DECISION DELEGATED TO HEAD OF PLANNING
--

Application No:	H12-1121-25	Applicant:	Mrs J Williamson
Proposal:	Proposed Vehicular Access		
Location:	Villa Farm Lutton Garnsgate Long Sutton		
Terminal Date:	6th March 2026

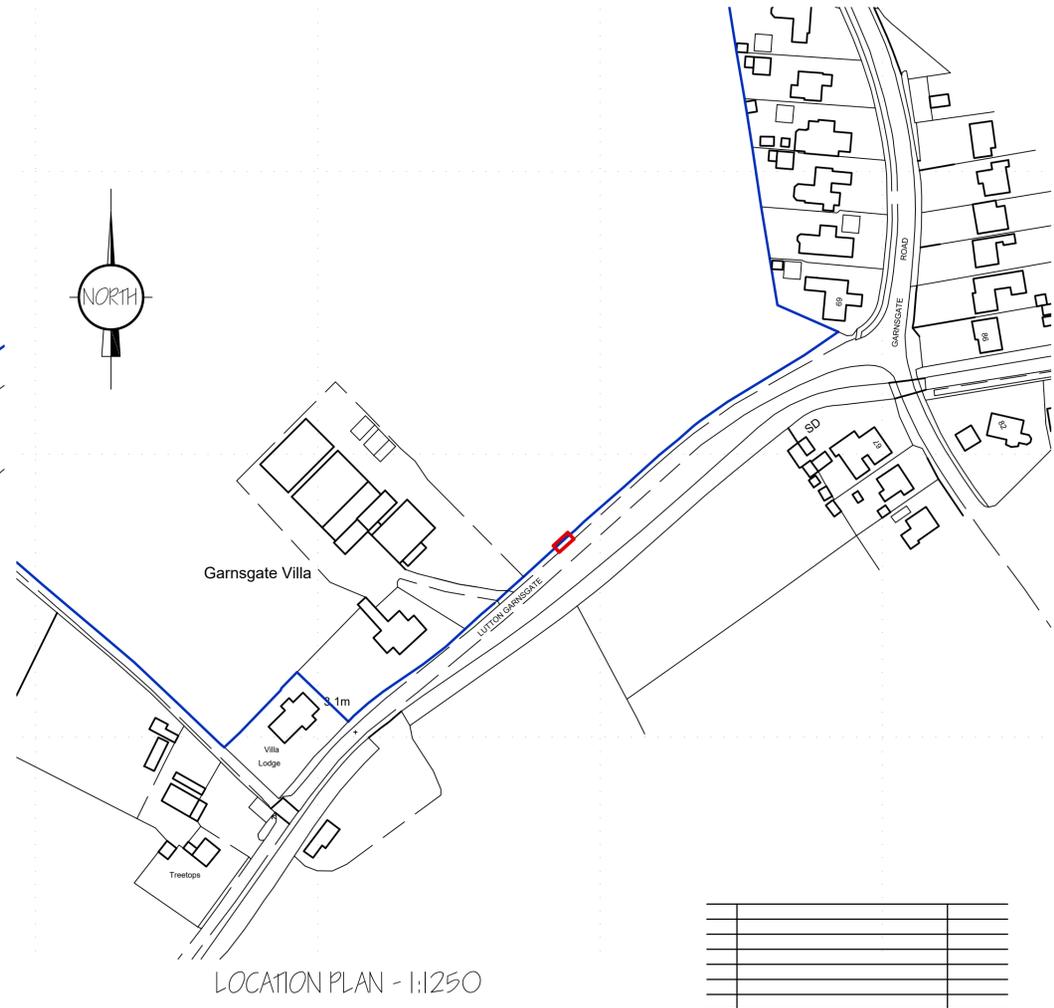
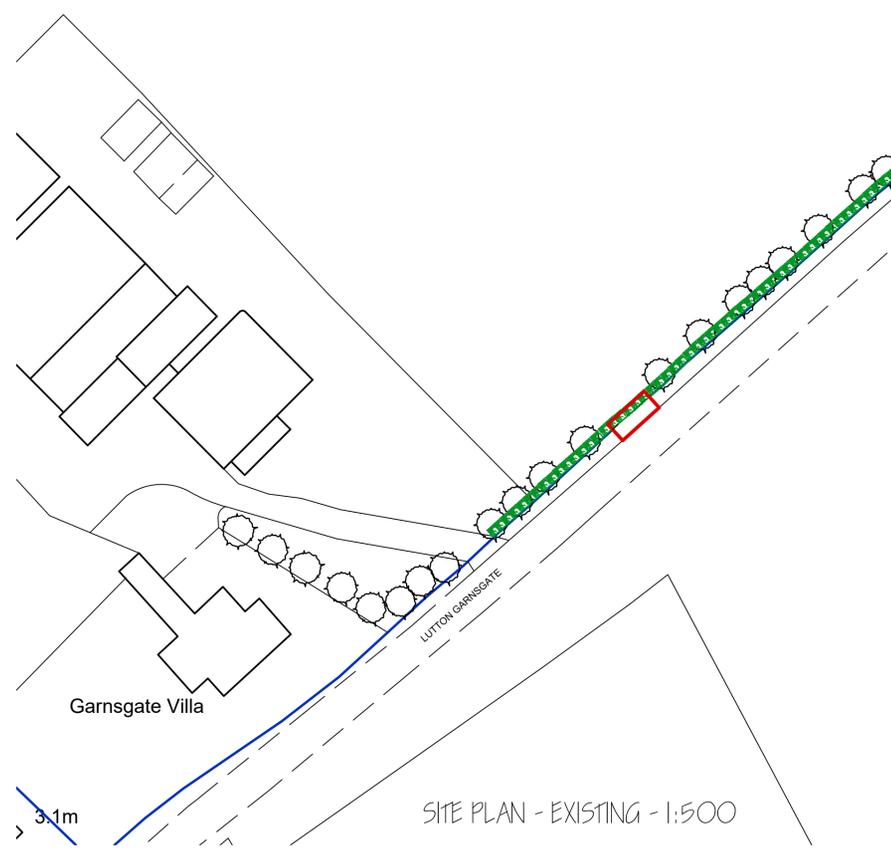
"As can be seen from the attached Tree Preservation Order, the proposal would appear to affect the Root Protection Area of at least one preserved tree and probably require some minor crown reduction too.

Firstly, it is strongly recommended that the access is moved to outside the Root Protection Area of any significant or protected trees.

Secondly if determined to pursue this Application as drawn; that the positions, canopy spreads and Root Protection Areas of all trees adjoining the proposed access are clearly shown to scale on a plan.

Most helpful to have a plan which shows the access in relation to the position of the trees the subject Lutton Tree Preservation Order No. 1 1959. The access is conveniently placed between a gap in the trees due to overhead cables but may affect the peripheries of the Root Protection Areas of the four closest trees flanking the access.

The Root Protection Areas of the closest trees to the proposed access are shown, but the limes are flanked by larger sycamore trees, which may also be affected.

Job Ref. 4382-25	Drawing No. 05B
Date SEPTEMBER 2025	Drawn SLD

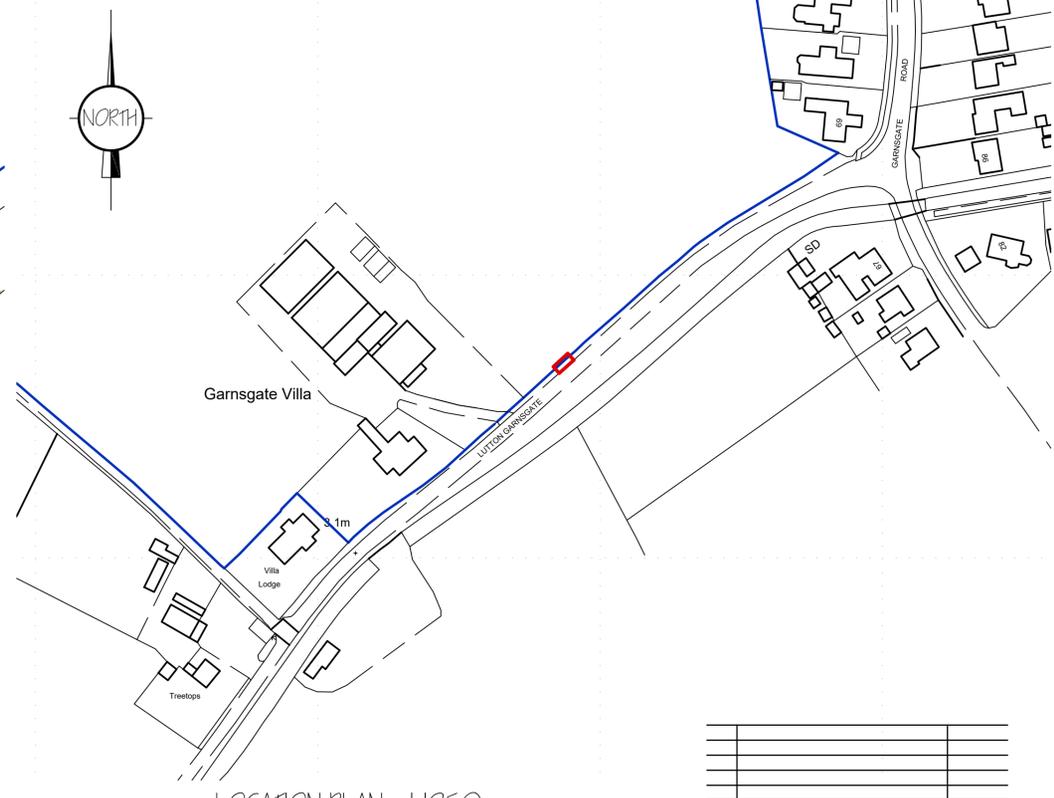
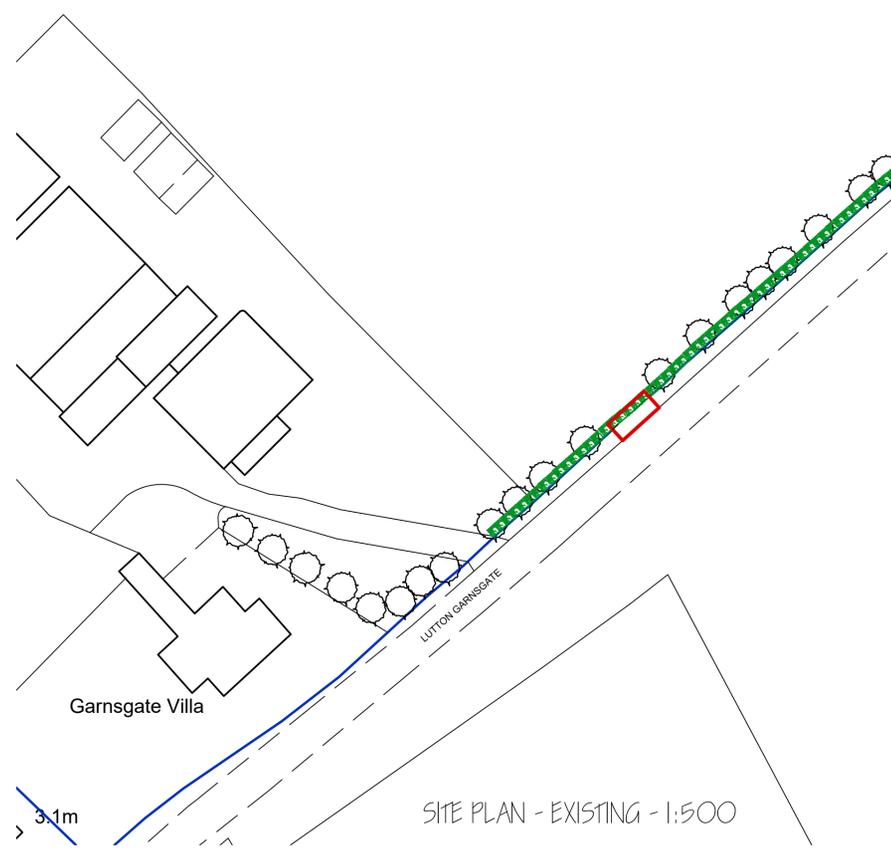
Additional information required: "Visibility needs to be demonstrated in accordance with Manual for Streets. A note should be added to the proposed site plan to say that the access will be constructed to Lincolnshire County Council Specification. Construction details do not need to be agreed at this time; a separate application will be required to Lincolnshire County Council once planning permission has been granted as the vehicle crossing will require a Section 184 agreement under the Highways Act 1980."

"No objection. Proposed vehicular access - Visibility has been demonstrated in accordance with Manual for Streets for a 60mph road. In order to maintain the visibility a condition is required to keep the visibility splay clear of obstructions. The access will be constructed to Lincolnshire County Council specification as detailed on the proposed site plan. The proposal will not have an adverse impact on the public highway.

Before the access is brought into use all obstructions exceeding 0.6 metres high shall be cleared from the land within the visibility splays illustrated on drawing number 4382-25-05A dated February 2026 and thereafter, the visibility splays shall be kept free of obstructions exceeding 0.6 metres in height.

The main thing is that the proposal plan clearly states 'New Access To be Of NO DIG Construction With All Materials To Be Placed Above Ground' please ensure that this is completely compatible with the other note on the plan which says 'New Field Access. To Be constructed to L.C.C. Highways Design and Specification.'

"No objections - Proposed vehicular access Visibility has been demonstrated in accordance with Manual for appropriate. The access will be constructed to Lincolnshire County Council specification as detailed on the proposed site plan. The proposal will not have an adverse impact on the public highway."
